City of Portland, Maine - Building or Use Permit

Permit No: 2013-00211	Date Applied For: 02/01/2013	CBL: 044 H001001
---------------------------------	--	----------------------------

Location of Construction: 66 STATE ST	Owner Name: CATHOLIC CHARITIES MAINE	Owner Address: PO BOX 10660	Phone:
Business Name:	Contractor Name: Welch Signage	Contractor Address: 7 Lincoln Avenue Portland	Phone (207) 883-6200
Lessee/Buyer's Name	Phone:	Permit Type: Signs - Permanent

Proposed Use: Same -Catholic Charities Maine - Counseling offices	Proposed Project Description: Erect 48" x 36" freestanding sign adjacent to State Street entrance.
---	--

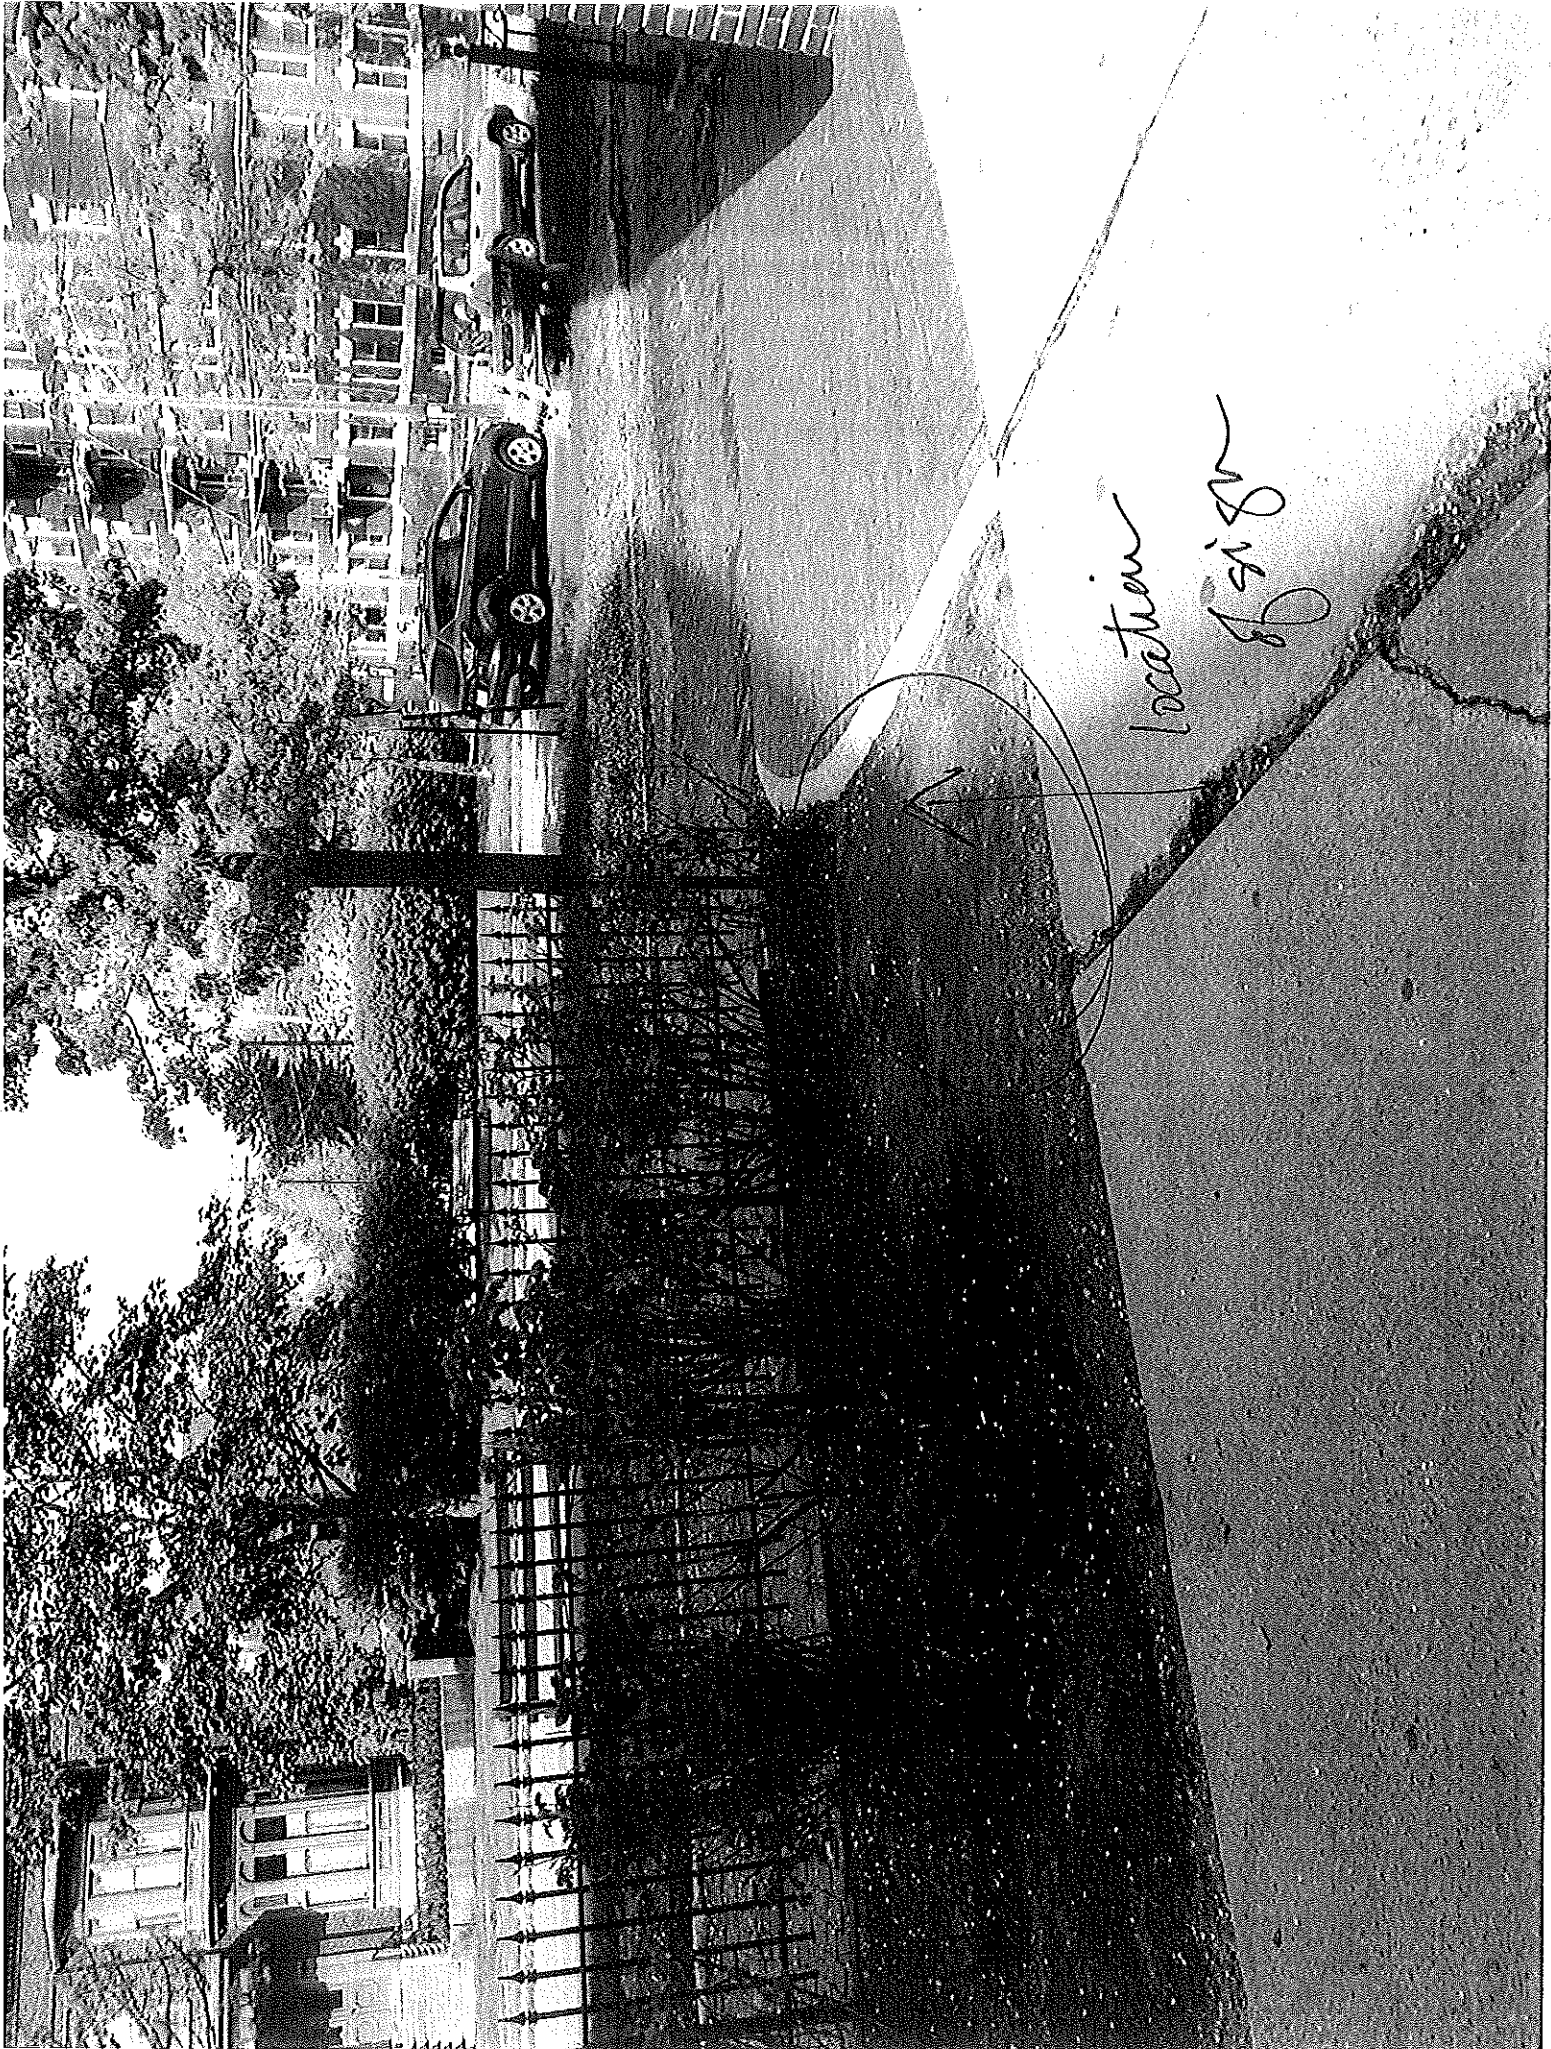
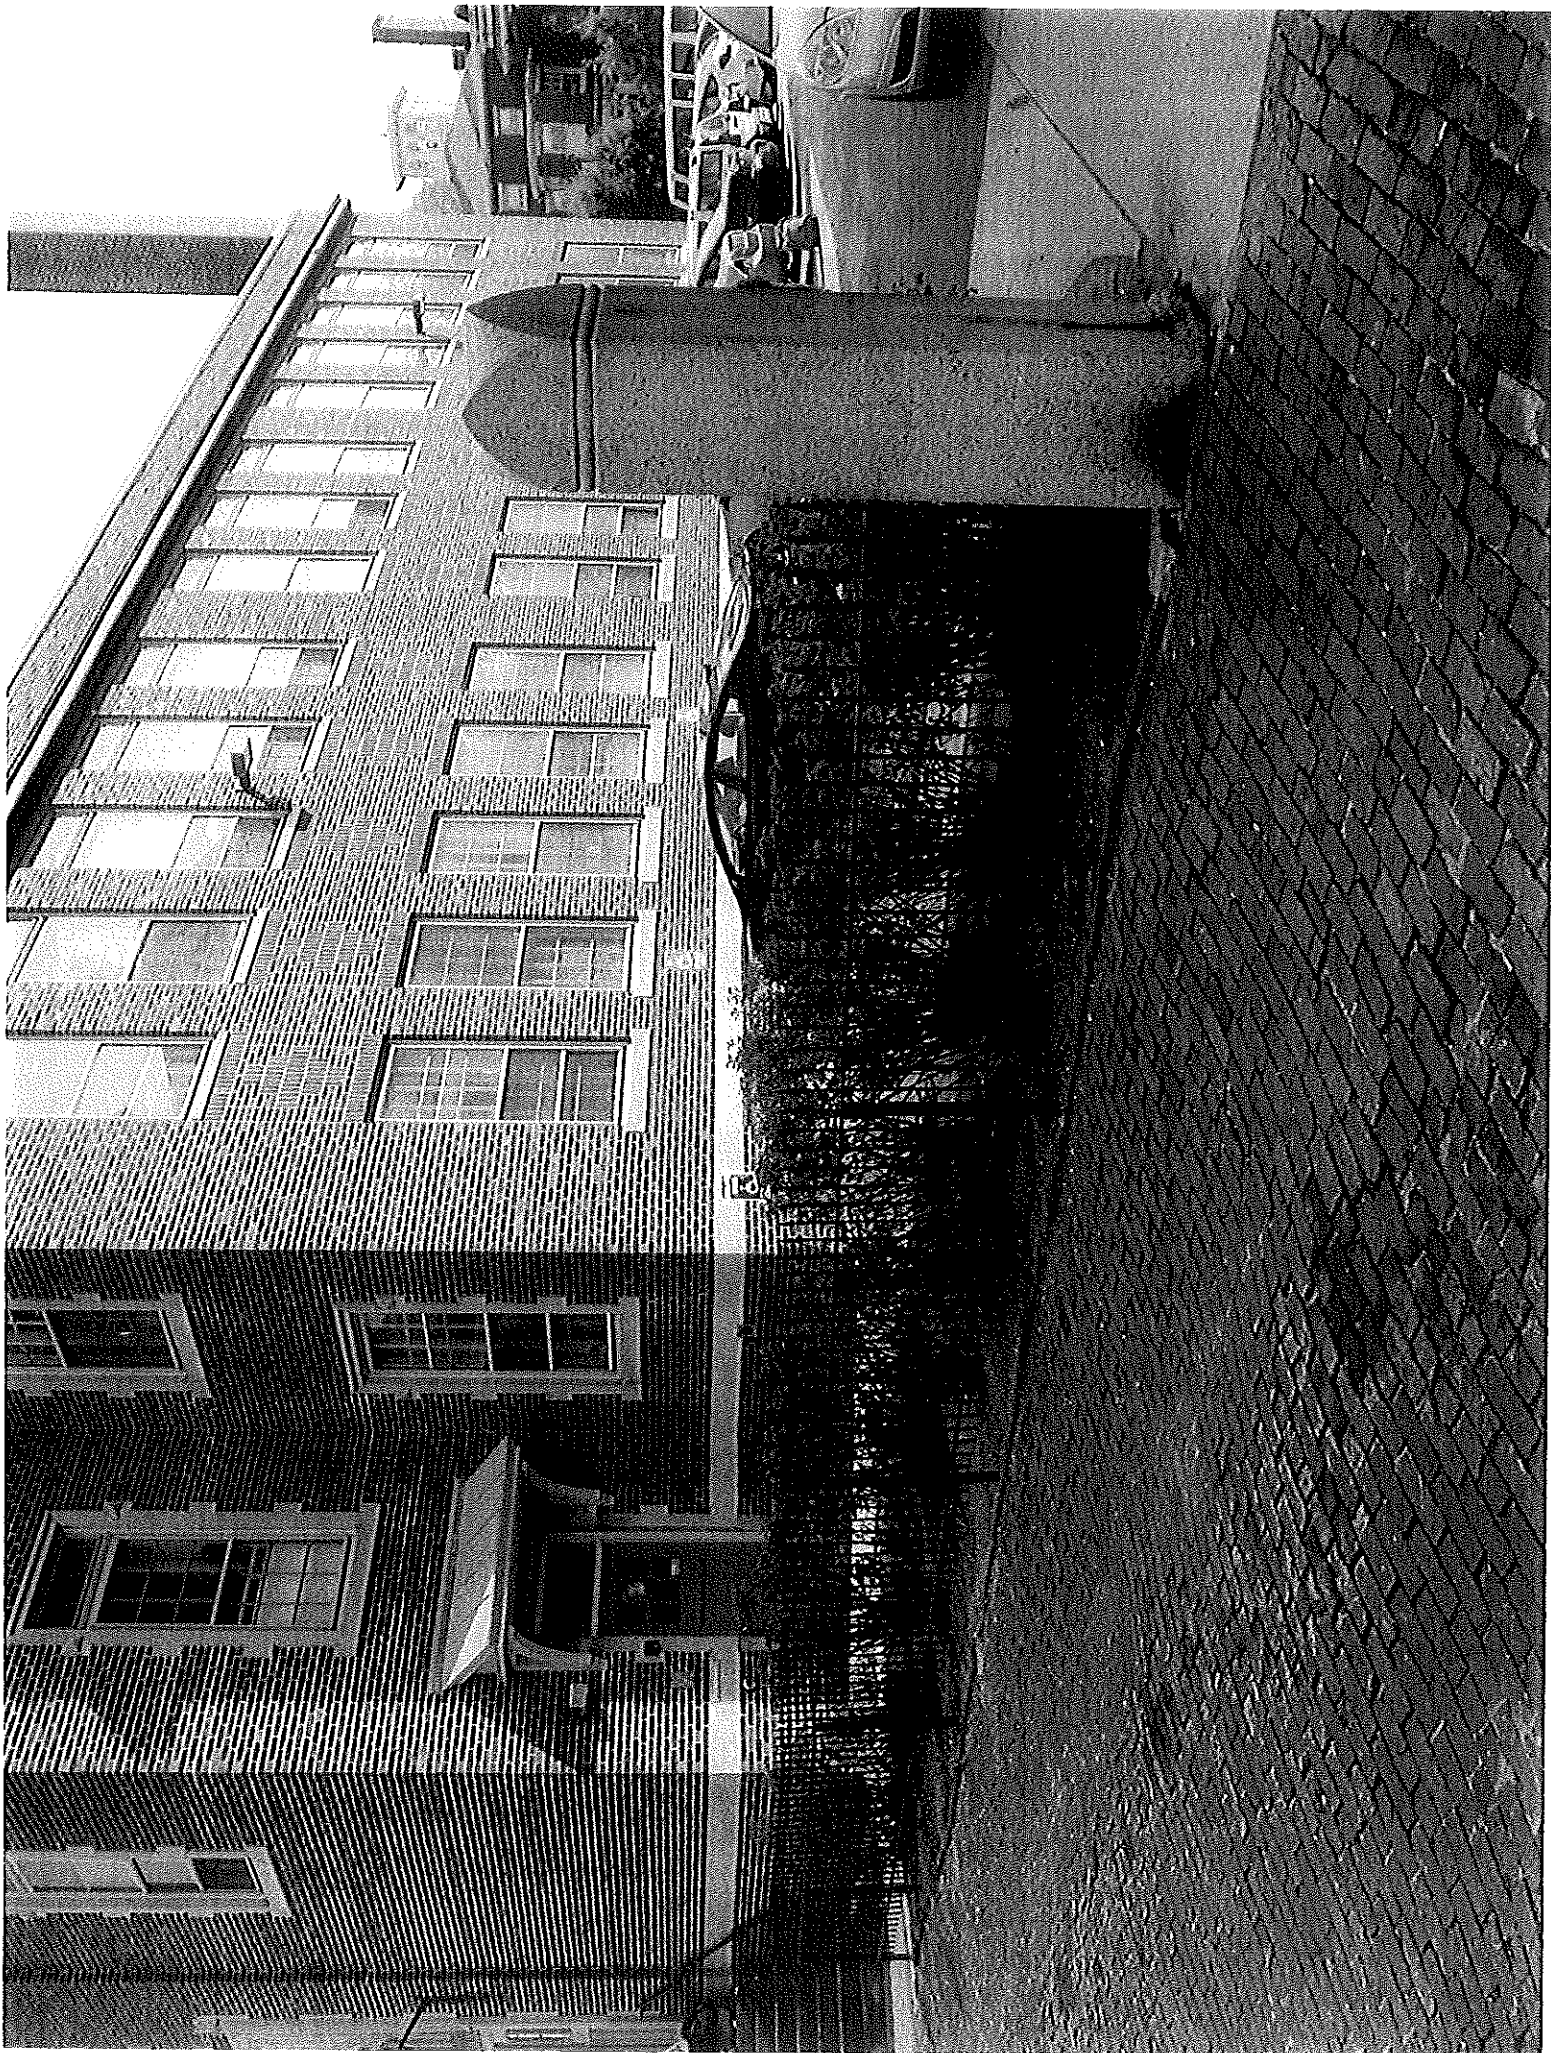
- 1) Lower edge of sign panel to be located just above iron fence pickets. Height of fence should be sufficient to allow for visibility, but no taller than necessary.
- 2) Sign to be located behind iron fence, in landscape bed near entrance. (See attached photo for location.) Sign may be positioned either perpendicular to State Street or parallel to State Street.
